Your Ref: 2017/90989  
Our Ref: T005017

13th April 2017

**HI Pylon Works, Slades Road, Bolster Moor, Huddersfield - Erection of 5 dwellings**

DRAWING TITLE
 SITE AND STREETSCAPE
 AS PROPOSED

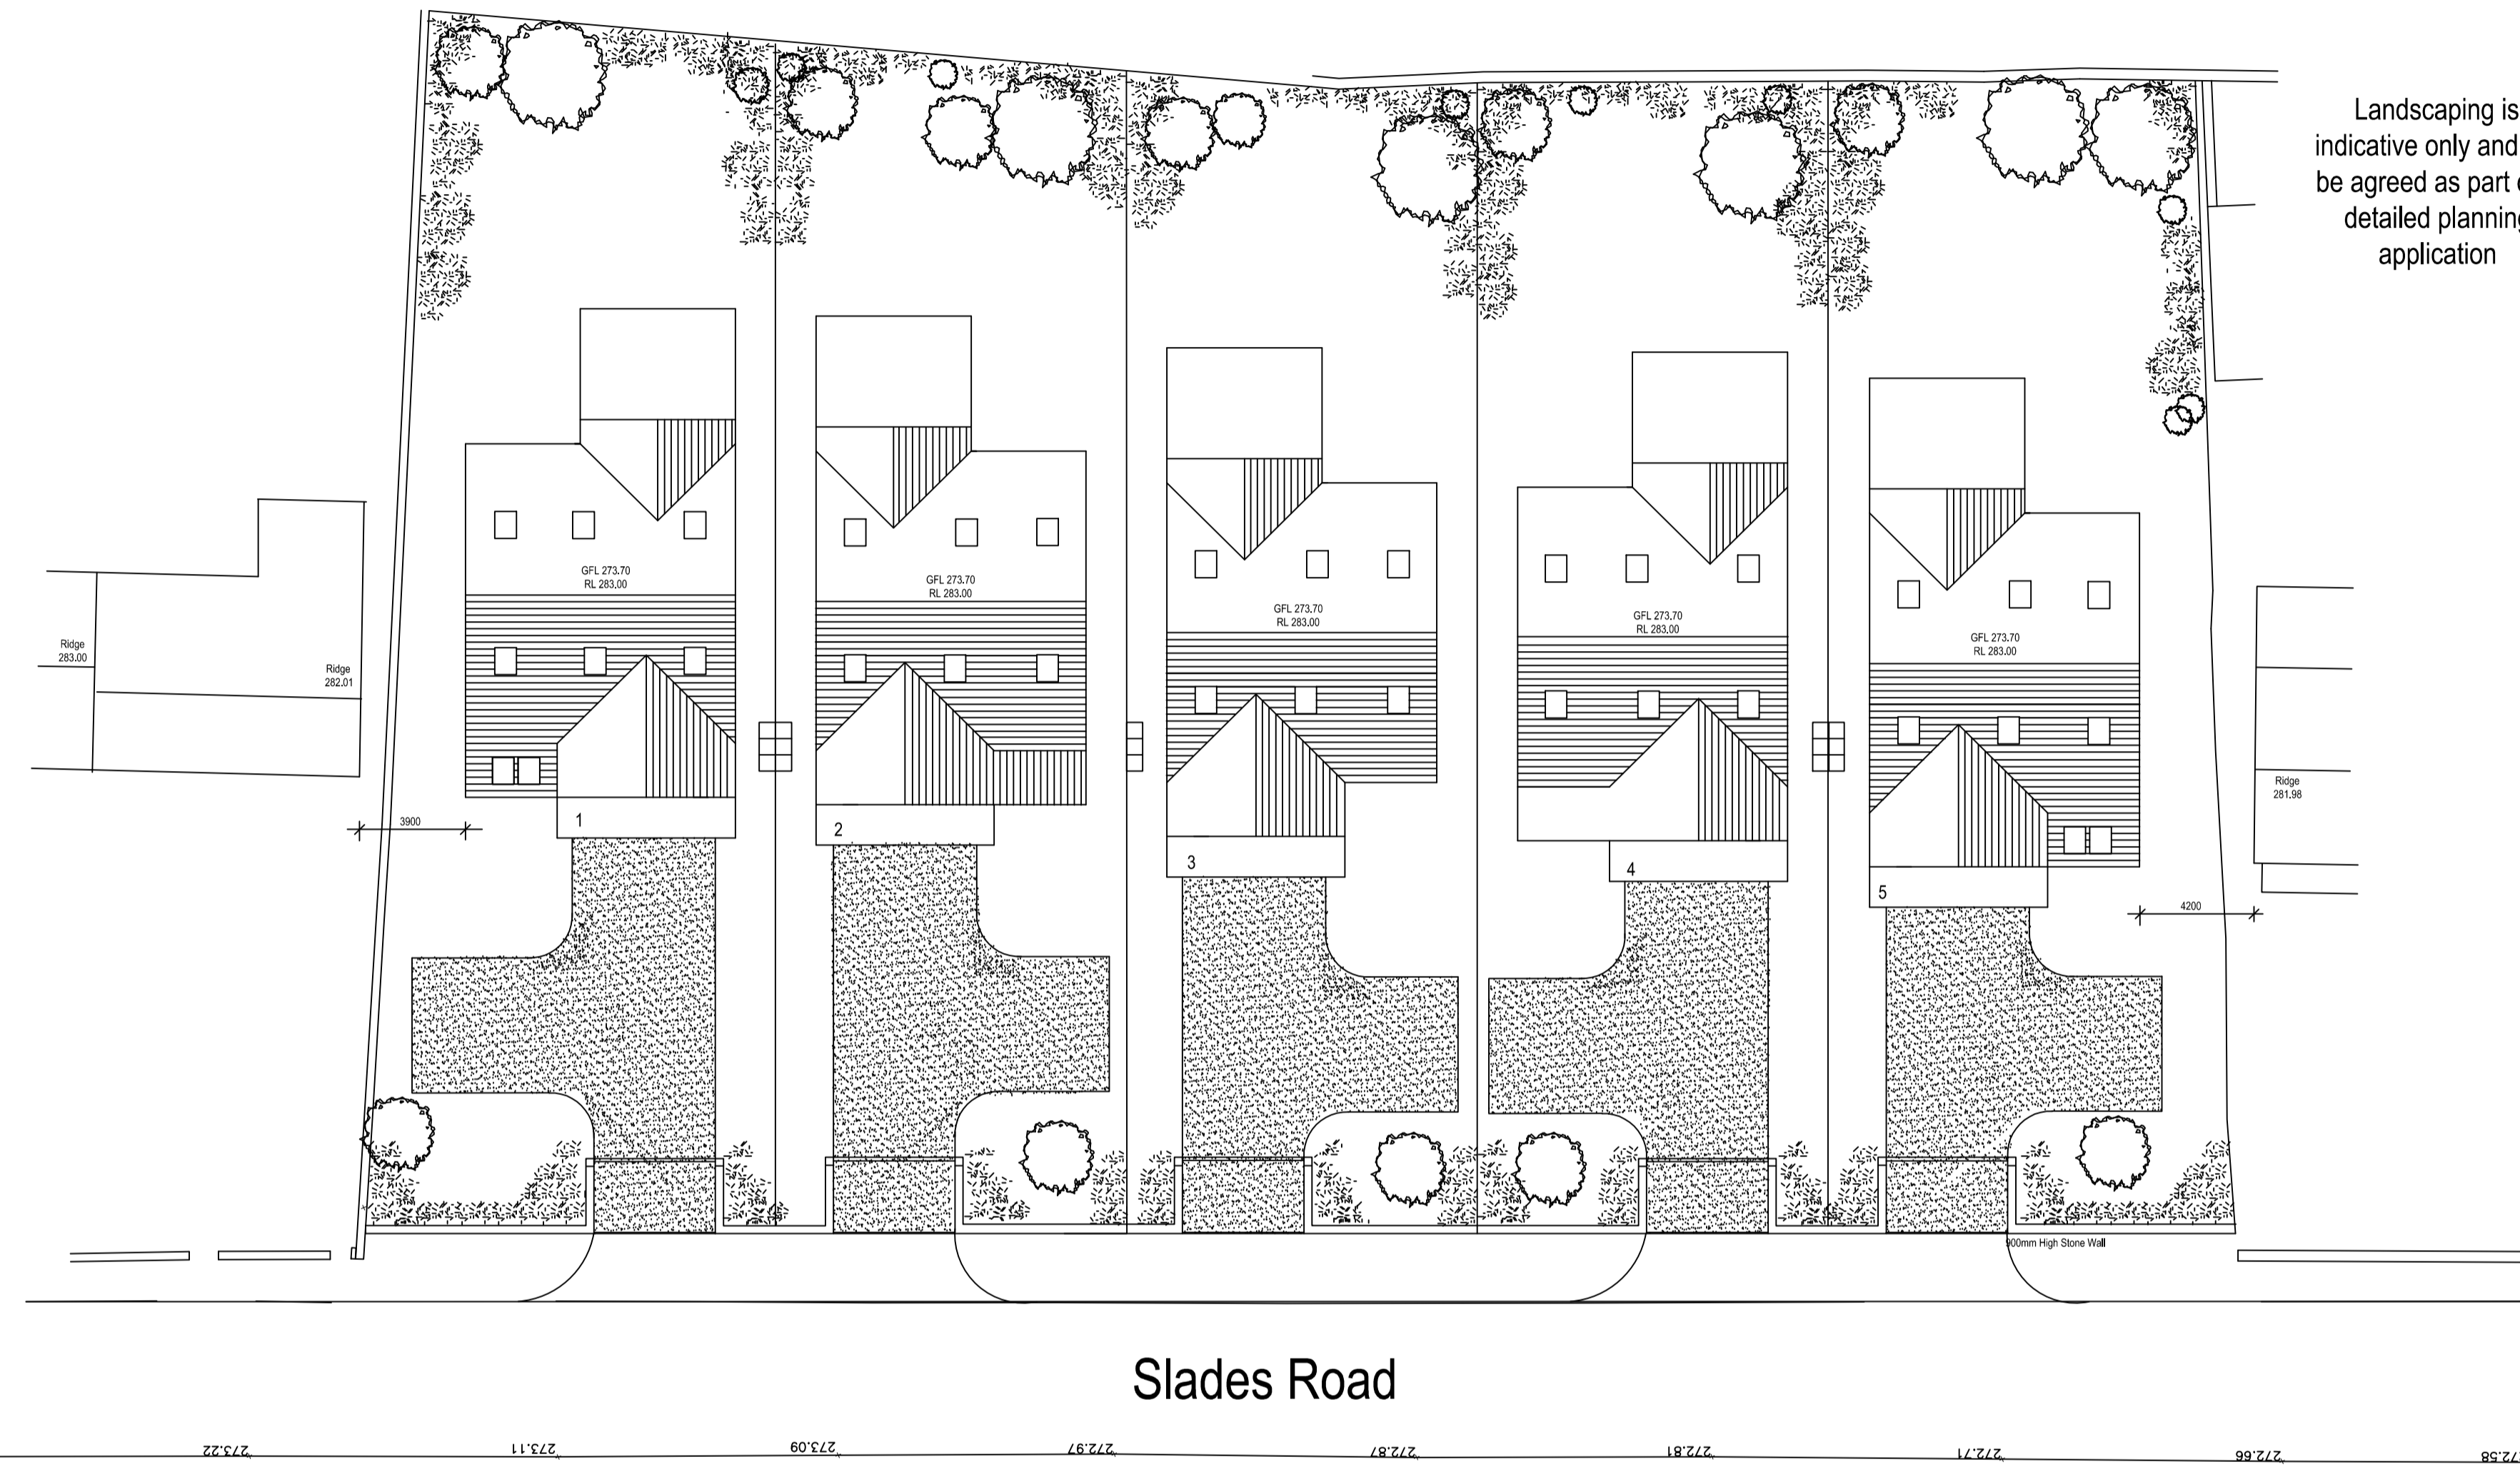
1) It is noted that the planning application form does not indicate the proposed means of surface water disposal, and there is no Flood Risk Assessment.

Sustainable development requires appropriate surface water disposal and Yorkshire Water promotes the surface water disposal hierarchy. The developer must provide evidence to demonstrate that surface water disposal via infiltration or watercourse are not reasonably practical before even considering disposal to a public sewer. The developer will be required to provide evidence of existing positive drainage to a public sewer from the site to the satisfaction of YWS/the LPA by means of physical investigation. On-site attenuation, taking into account climate change, will be required before any discharge to the public sewer network is permitted. Surface water discharges to the public sewer must have a minimum of 30% reduction based on the existing peak discharge rate during a 1 in 1 year storm event.

2) On the Statutory Sewer Map, there is a minor small diameter public combined sewer recorded to cross part of the red line site boundary. In this instance, YWS would look for this matter to be controlled by Requirement H4 of the Building Regulations 2000, but trees should not be planted within 5 meters either side of the sewer's centre line.

**No development shall take place until details of the proposed means of disposal of surface water drainage, including details of any balancing works and off -site works, have been submitted to and approved by the local planning authority . The details shall include :-**

- a) evidence to confirm the reasons for rejection of other methods of surface water disposal ;**
- b) evidence of existing positive drainage to a public sewer from the site ; and**
- c) the means of attenuating surface water to as close to greenfield rates as reasonably practical and in any event , by a minimum reduction of 30% reduction based on the existing peak discharge rate during a 1 in 1 year storm event.**
